45 Hearnese Lake Road, Woolgoolga
Proposed Land Subdivision

Preferred Project Report

September 2009

RESIDENTIAL SUBDIVISION
LOT 21, DP714858 HEARNES LAKE ROAD, WOOLGOOLGA
SEPP 26 - LITTORAL RAIN FOREST

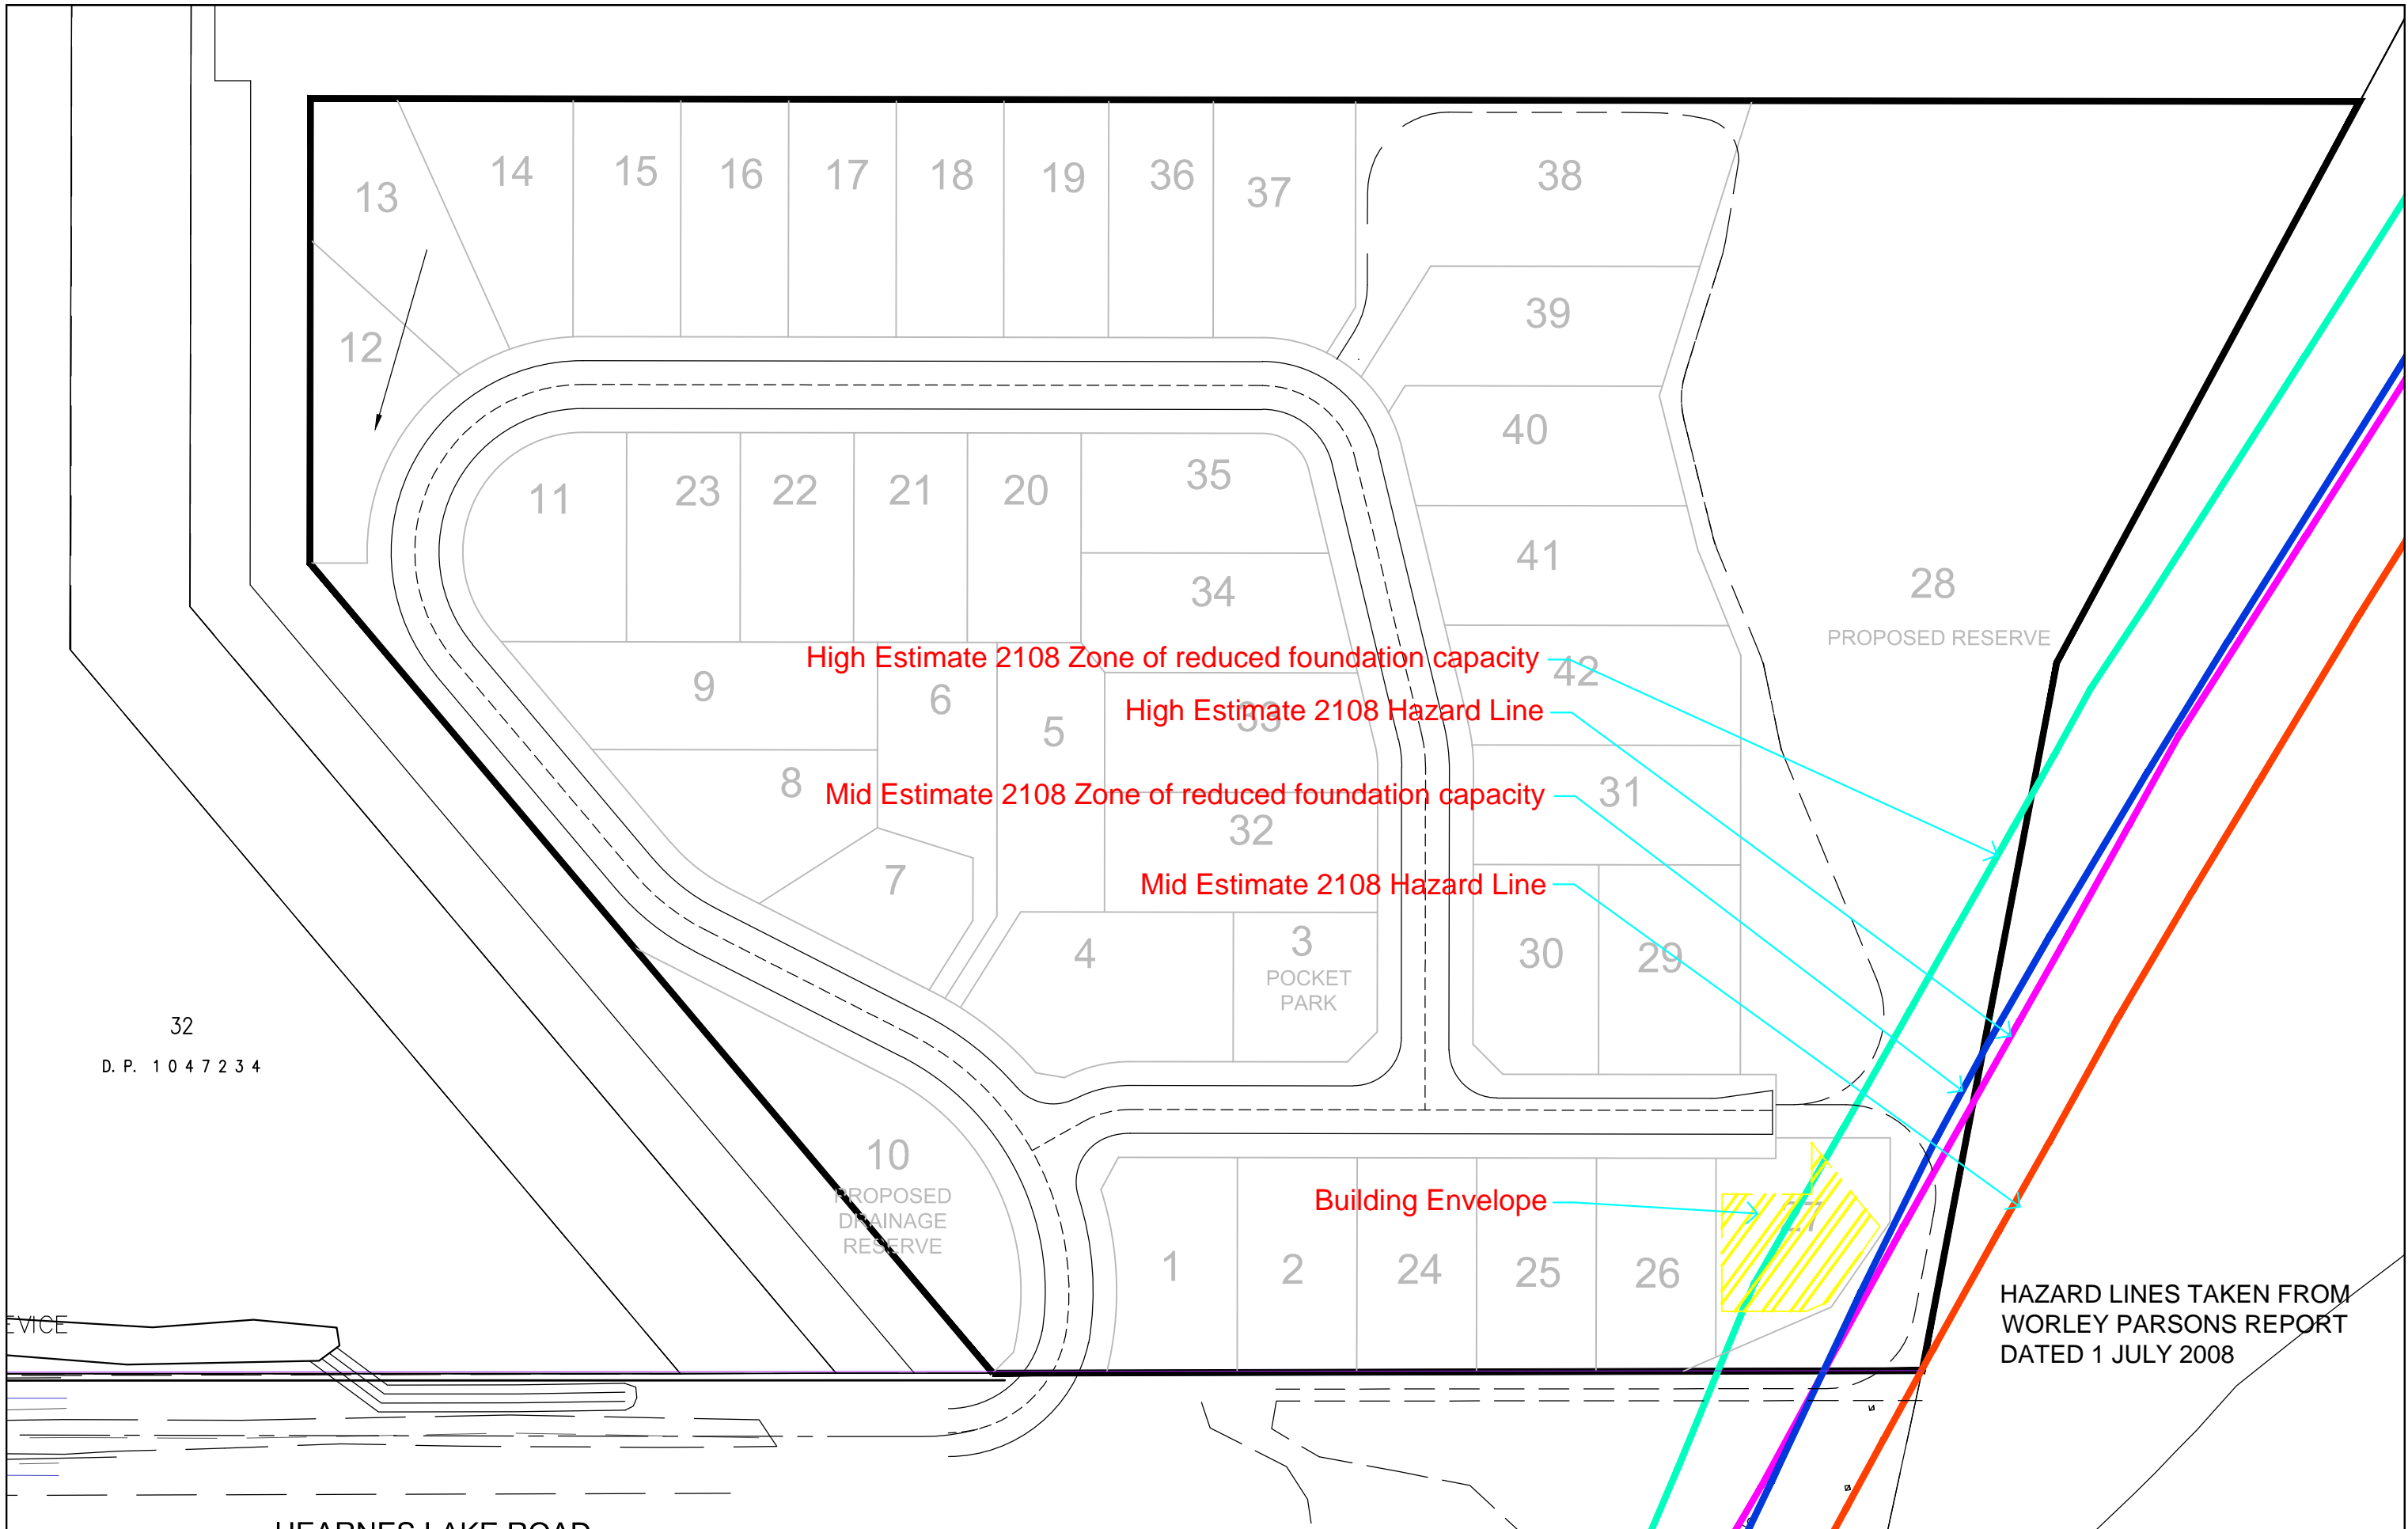
No.	Authority	Issue Raised	Submission	Response
1.1	NSW Dept. of Planning	<p>1. <u>Environmental buffers and preservation of Austral Toadflax (Thesium)</u></p> <p>The buffer to the SEPP 26 littoral rainforest and freshwater wetlands is insufficient. The subdivision has the potential to have a negative impact on the integrity of the rainforest and wetland communities as a result of edge effects.</p>	<p>Applicant to amend boundaries of proposed Lots 43, 32, and 30 to provide for a minimum 50m buffer to the SEPP 26 littoral rainforest.</p> <p>Proposed Lot 29 is to be deleted and incorporated into Reserve Lot 28.</p> <p>A covenant is proposed to be registered on the title of Proposed Lot 27 restricting building within the buffer zone.</p>	<p>Following further discussions with Coffs Harbour City Council and NSW Department of Planning it is agreed that the proposed lot layout be amended to provide for a 50m buffer to the SEPP 26 littoral rainforest. The buffer provided to the freshwater wetlands is shown as the agreed vegetation line. The agreed vegetation line was determined as the appropriate buffer required by CHCC ecologist Mark Graham and re confirmed by CHCC ecologist Gary Leonard. The agreed vegetation line has also been assessed by applicant's ecologist Peter Richards from Eco Logical Australia and is considered appropriate. WBM Oceanics' site specific study for storm water management also concurs the agreed vegetation line is appropriate.</p>

<p><u>(Thesium)</u></p> <p>Lot 27 is partially intersected by a 50 metre buffer to the 3.5m AHD contour, as specified in the Hearne's Lake DCP. This is not supported.</p>	<p>A building platform of 460m² has been applied to Lot 27.</p>	<p>to Lot 27.</p>

<p>Proposed Lot 27 has been reduced from an area of 1093m² which provides for an unencumbered building platform of 460m² (shown as hatched) while respecting the 50m buffer to SEPP 26 by reducing its size and incorporating a covenant to restrict the building footprint.</p> <p>This is reflected in Appendix 1, Map 24 SEPP 26 – Littoral Rainforest.</p>

1.3	NSW Dept. of Planning	1. <u>Environmental buffers and preservation of Austral Toadflax</u>	<p>Applicant to amend Lot 27 to be outside the 50m buffer from RL 3.5 AHD.</p>	<p>Applicant has amended Lot 27 to be outside the 50m buffer from RL 3.5 AHD.</p> <p>A building platform of 460m² has been applied</p>
